From: Grace Palmer [REDACTED]
Sent: 01 November 2021 16:35
To: Simon Davis
Subject: RE: Planning Consultation on: BN/134/21/DOC
Attachments: 18158 Addendum Letter Report Rev2_ISSUE.pdf; 108.5009.505.E.pdf; 108.5009.503.G.pdf; 108.5009.502.F.pdf; 108.5009.504.F.pdf; 108.5009.501.D.pdf; 108.5009.751.B.pdf; 108.5009.705.G.pdf; 108.5009.706.F.pdf; 108.5009.704.A.pdf; 108.5009.703.A.pdf; 108.5009.551.F.pdf; 108.5009.552.B.pdf; 108.5009.506.F.pdf; 108.5009 - PERMEABLE PAVING 1in100.pdf

The engineers have jumped on this round of comments and responded/updated drawings with the typos or missing information to hopefully finalise queries now. See response in blue below for ease and attached updated drawings.

Please see comments below from drainage. Please provide the requested items/amendments to me by the 12th November.

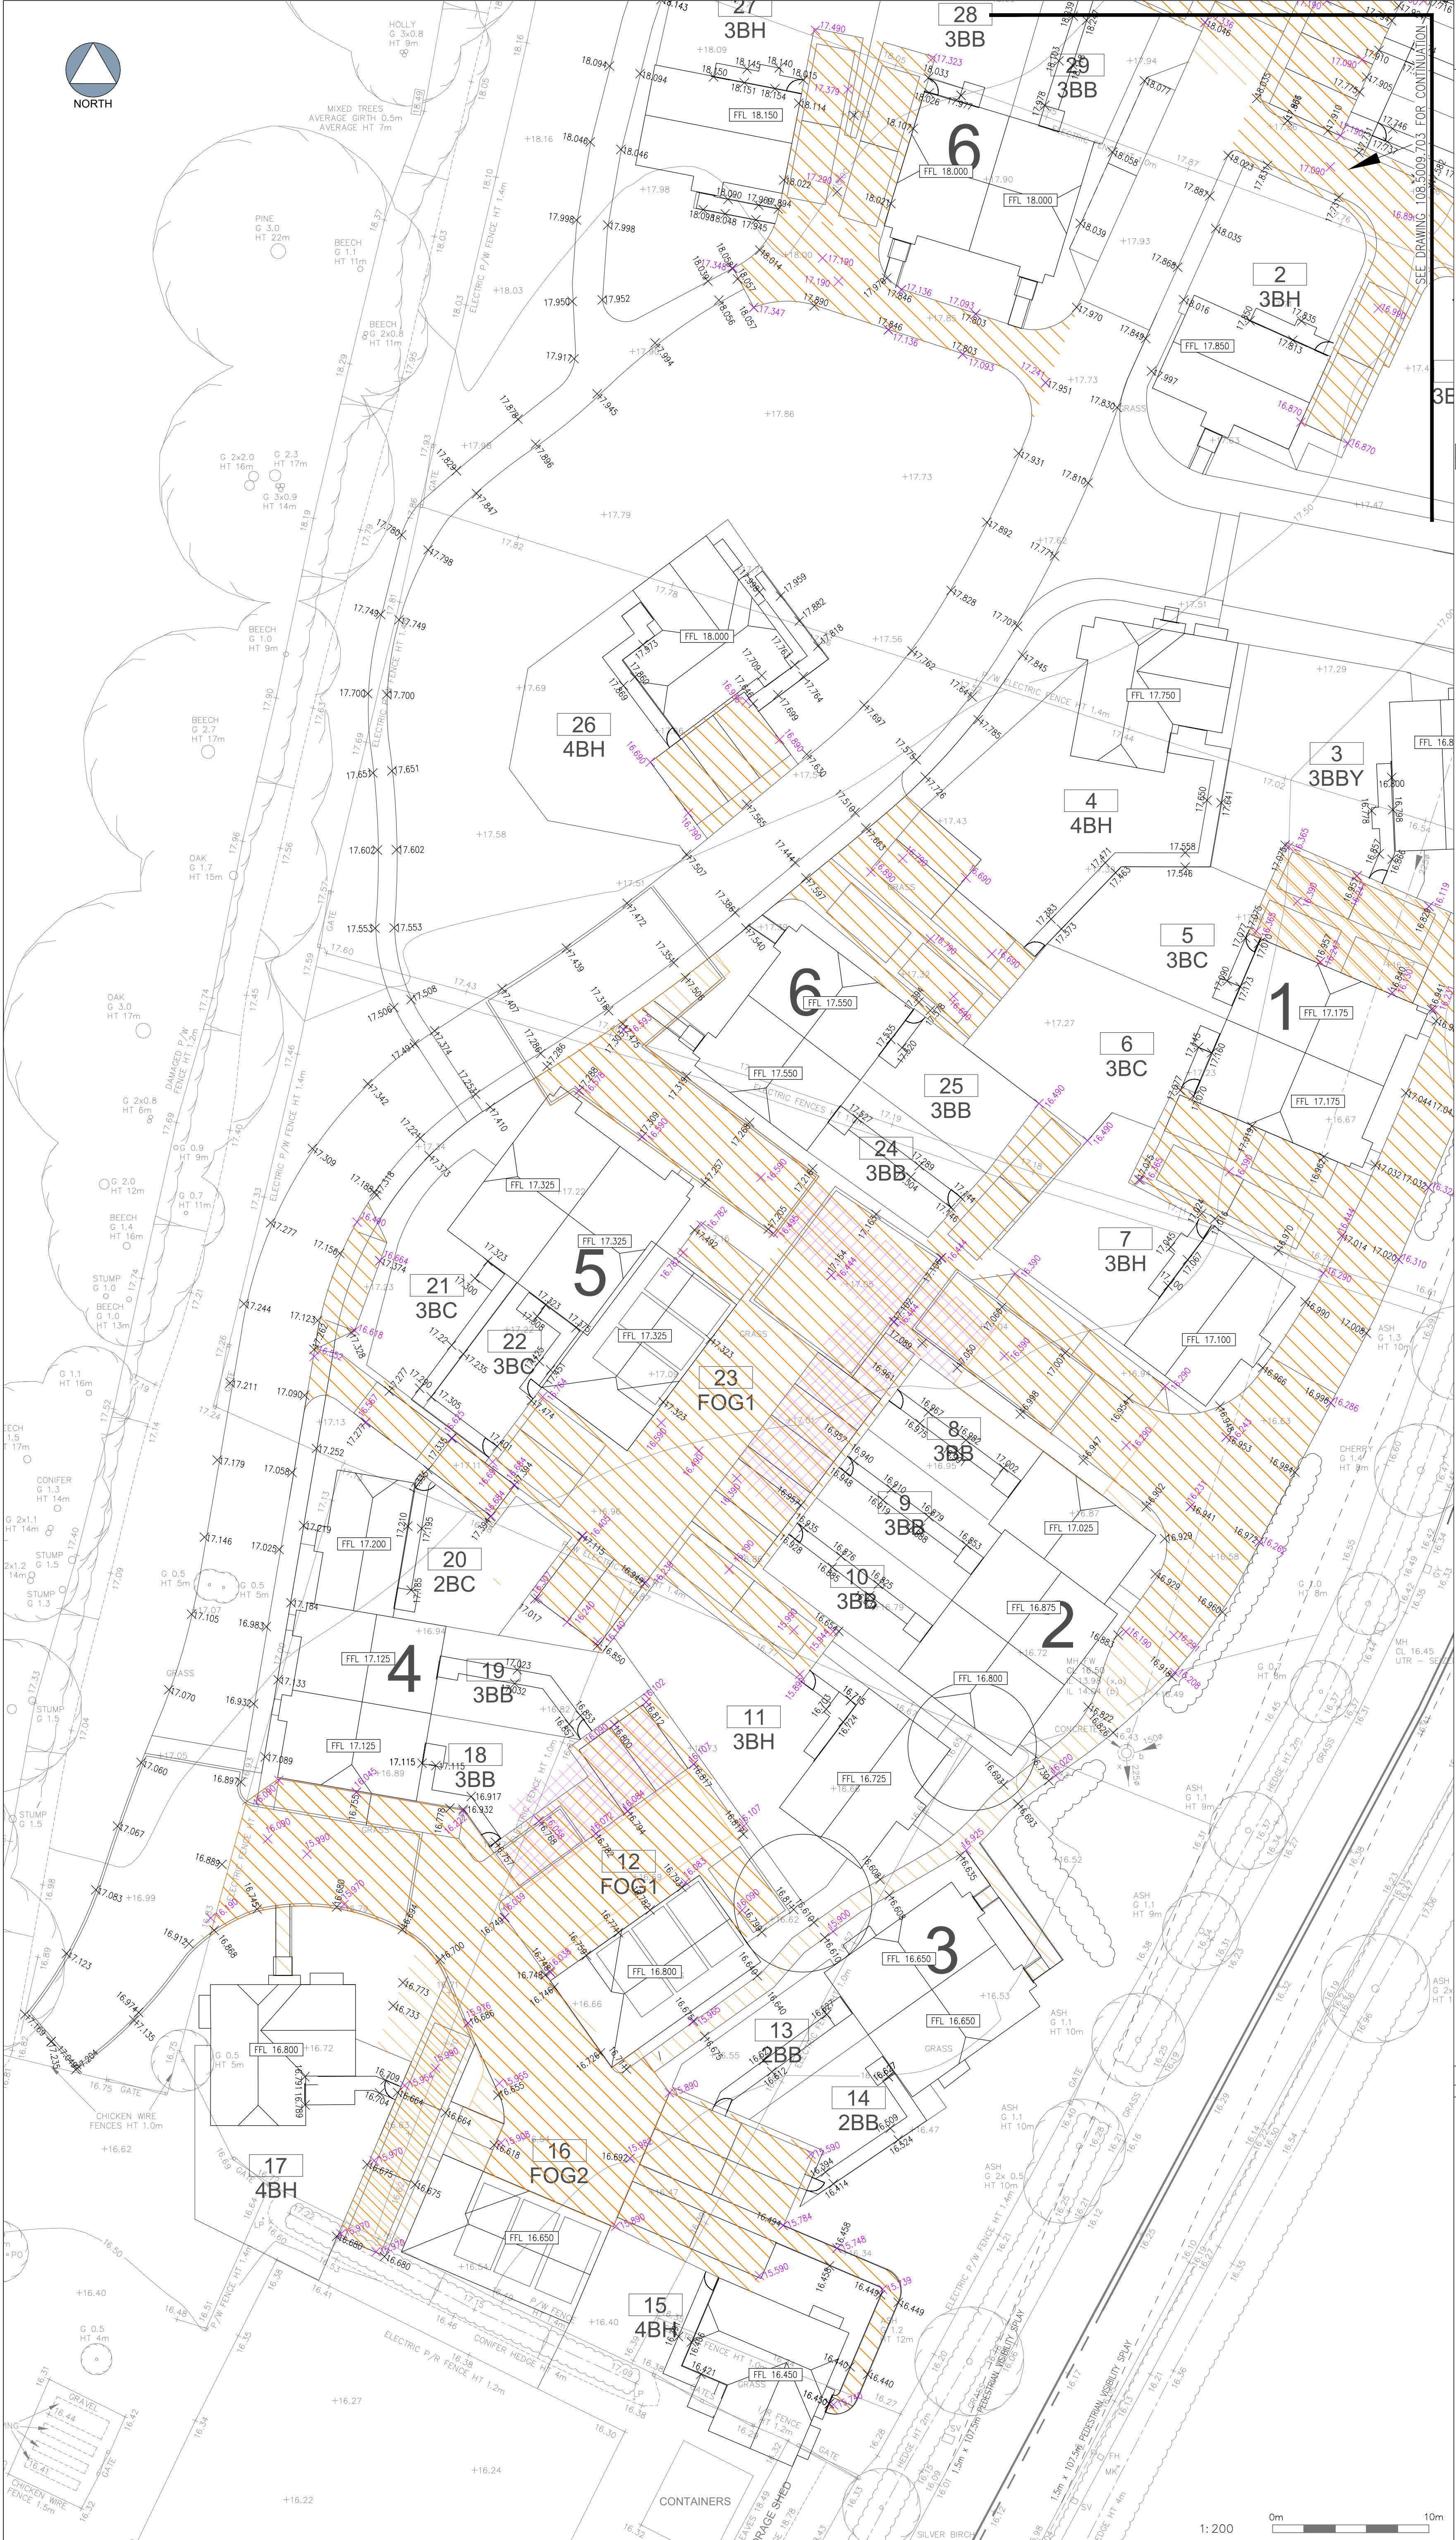
7. Capping layer below type 3 on the permeable paving must state “no fines”. Please also clearly label the base geotextile.

Permeable paving specification updated to state ‘no fines’ on capping layer – drawings 703, 704, 705, 706, 751, 552 and drawings 501-506 updated accordingly

Checked By RW	Checked Date 21.04.21	Drawn By RD	Drawn Date 20.04.21
Client Drawing No.		Scale 1:20	(AT A1 SIZE)
PBA Drawing No. 108.5009.551			Revision F

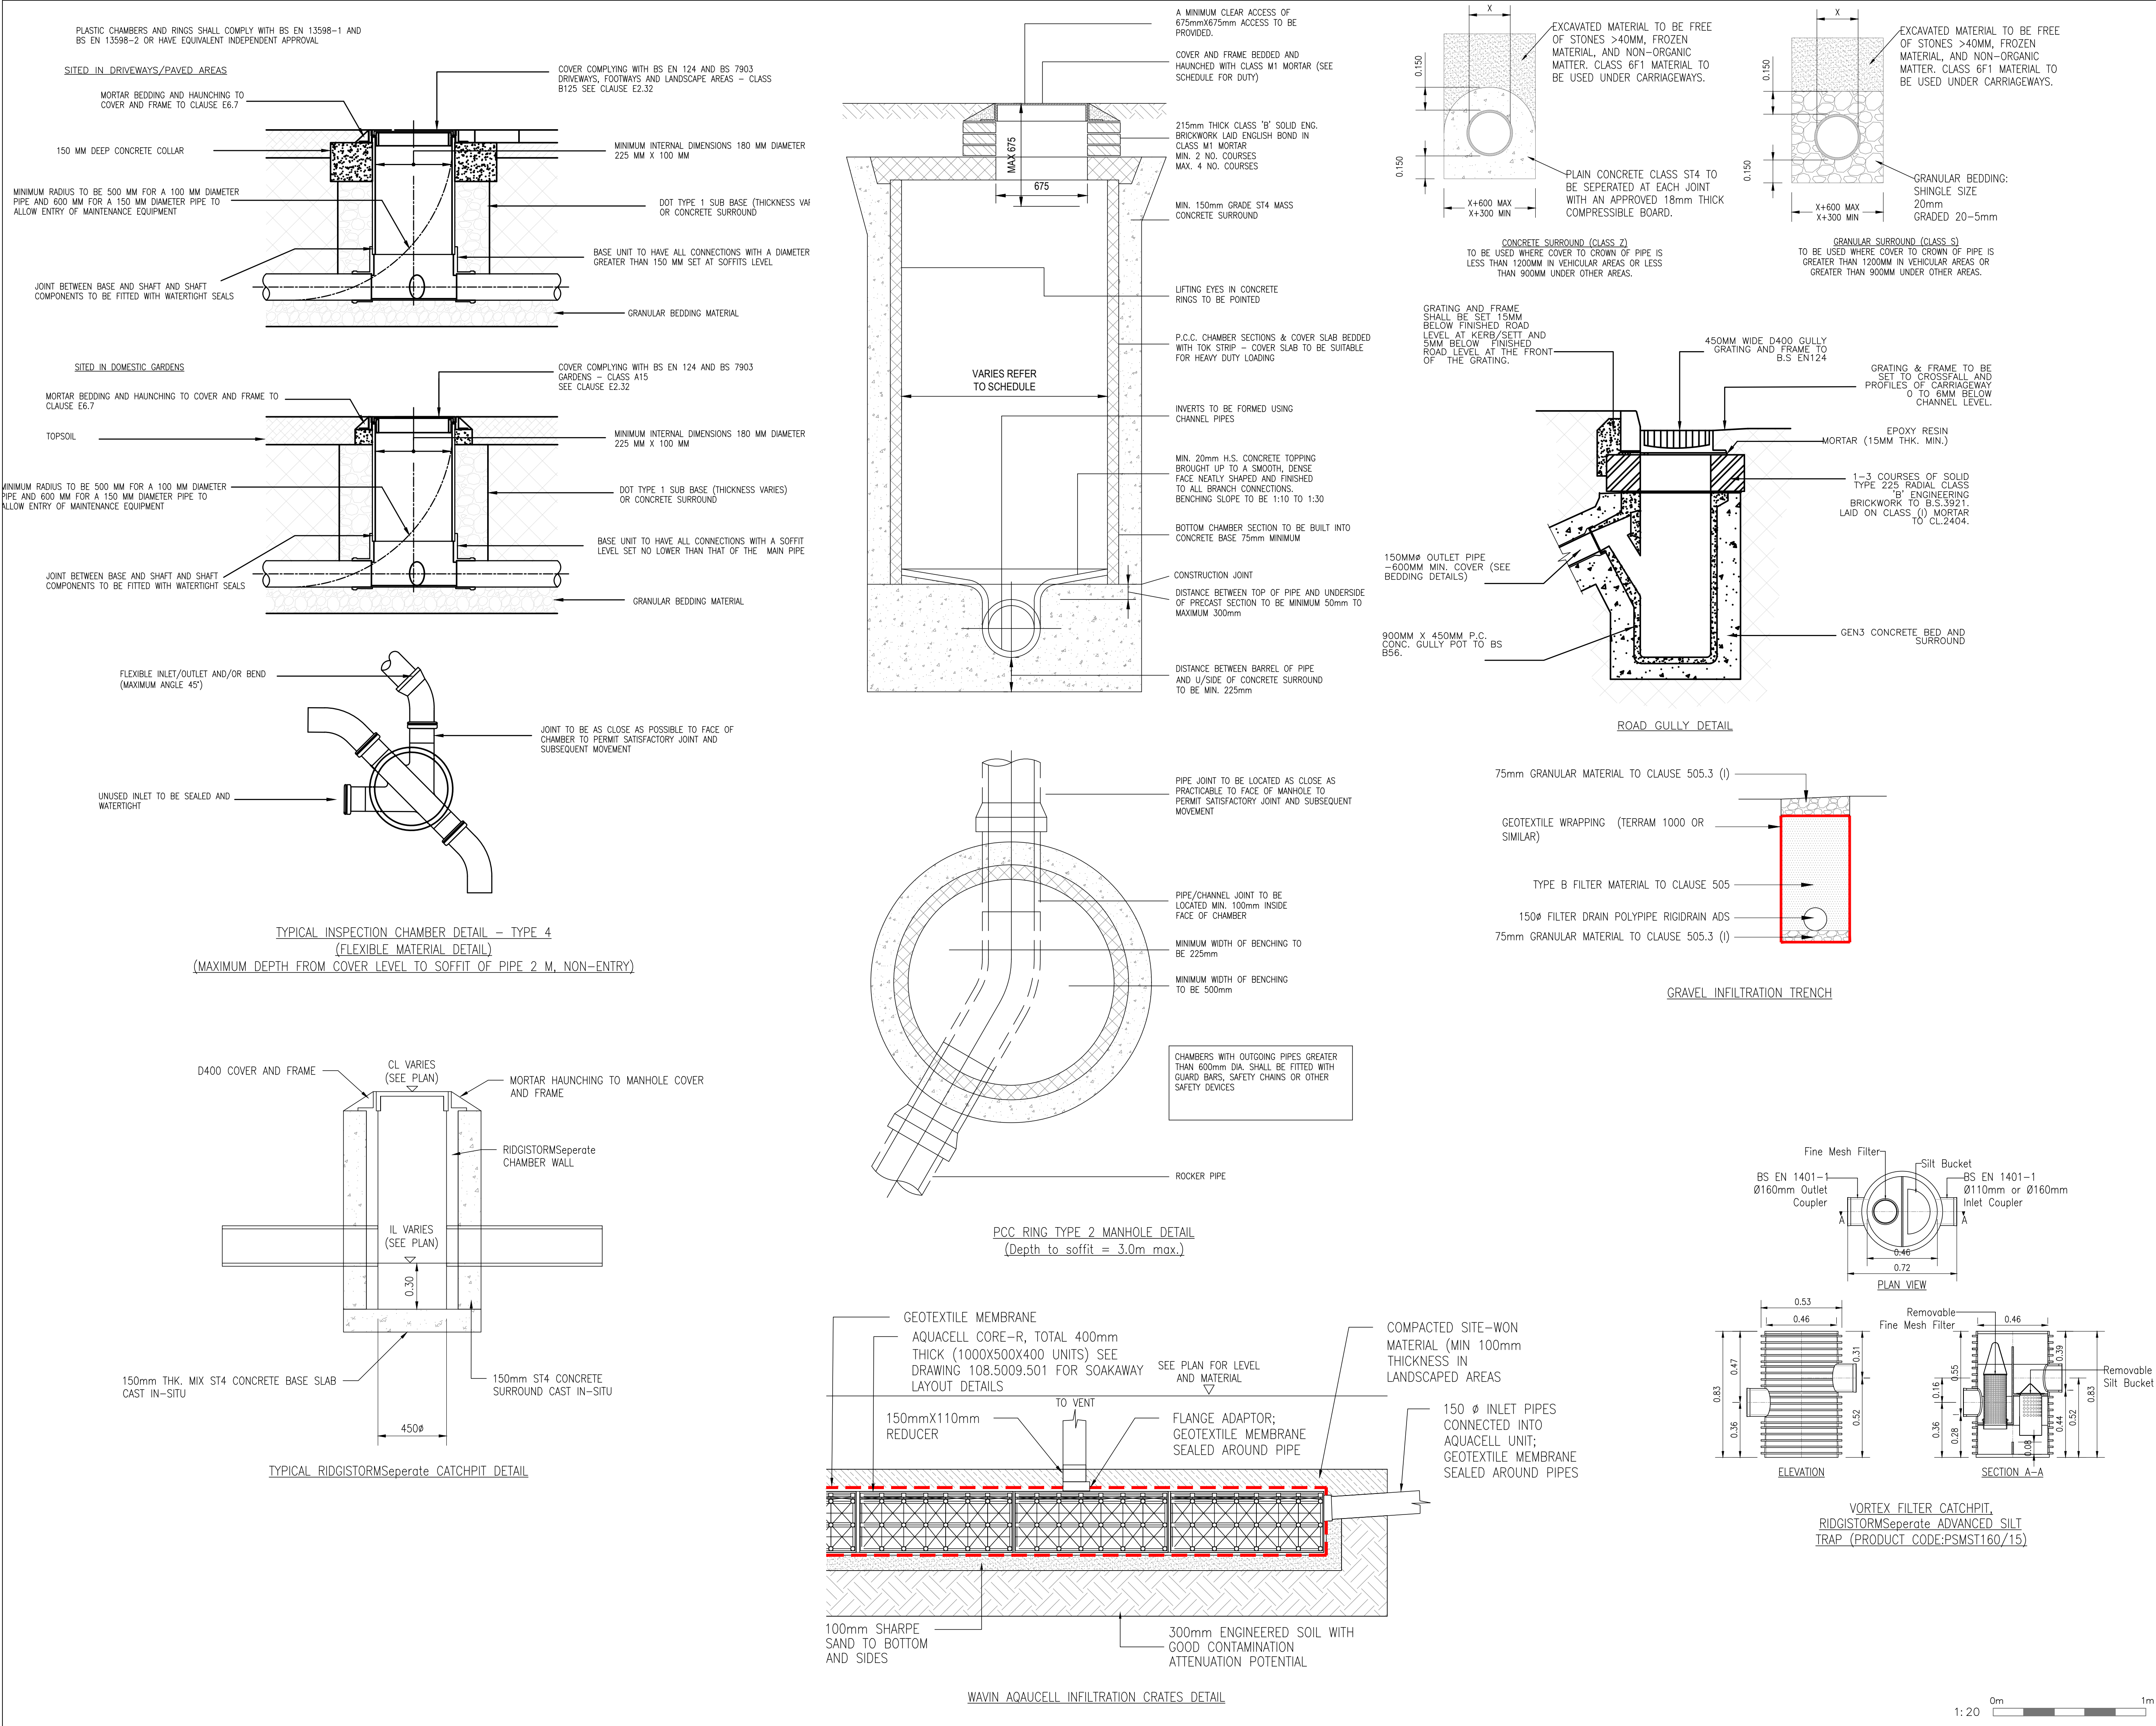
8. The soakaway construction detail needs to be improved. As crate depth varies, the detail should not state total 400mm thick, and should instead state that the depth varies and reference the plans that depth is detailed on. Minimum cover depth should be stated.

9. Please provide a construction detail drawing of granular soakaways.

Note on soakaway construction detail amended to state: *AQUACELL CORE-R 1000X500X400 UNITS, EXACT DEPTH AND AREA OF SOAKAWAYS VARY, SEE DRAWING 108.5009.501 FOR SOAKAWAY LAYOUT DETAILS.*
Drawing 551 updated accordingly

A granular soakaway detail is shown on drawing 551.F
